RE: Bjorkman Administrative Conditional Use Application (ACU-20-00003)

On October 12, 2020 Kittitas County Community Development Services (CDS) received your application for the above Conditional Use Permit. The application packet as submitted has been deemed **incomplete** by CDS until such time as the following are submitted:

JASON BJORKMAN PROPERTY

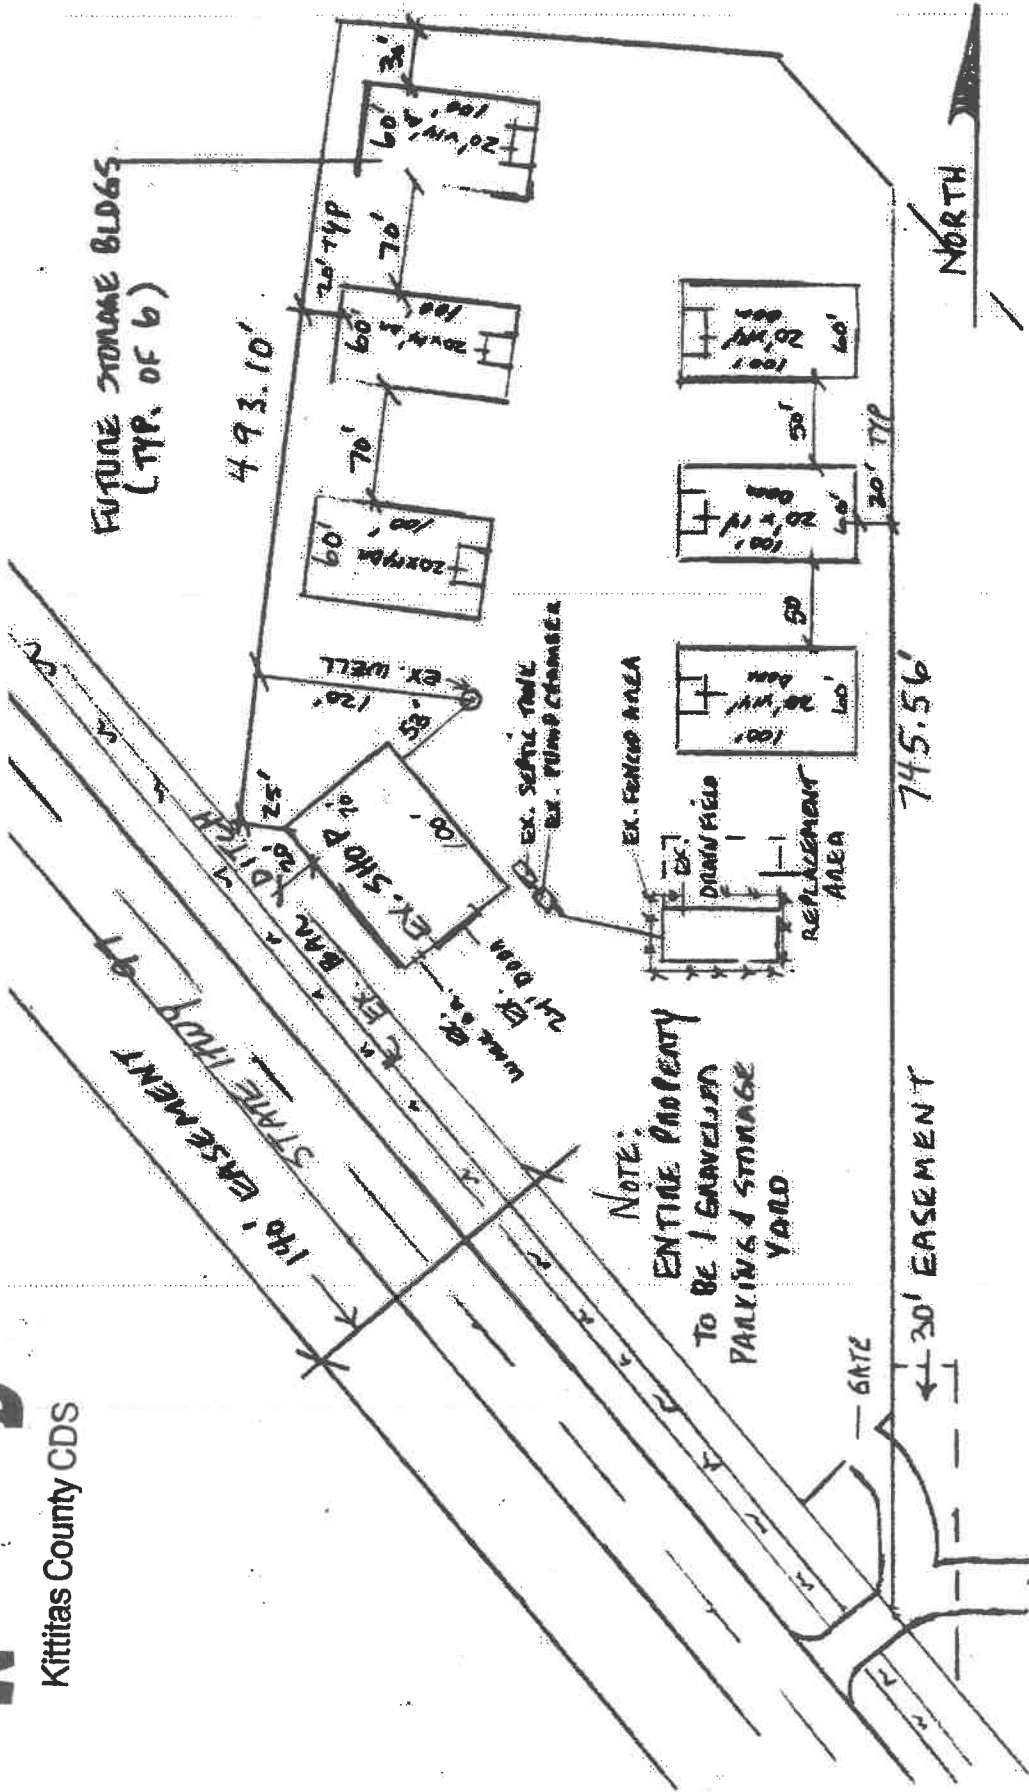
- a. Revised site plan depicting :
 - The orientation of the storage buildings, specifically the face of each storage structure.
 - Additional detail in regards to the setbacks from property lines, points of access, roads and parking areas.
 - Location of the existing well, septic tank, drainfield and the drainfield replacement area.
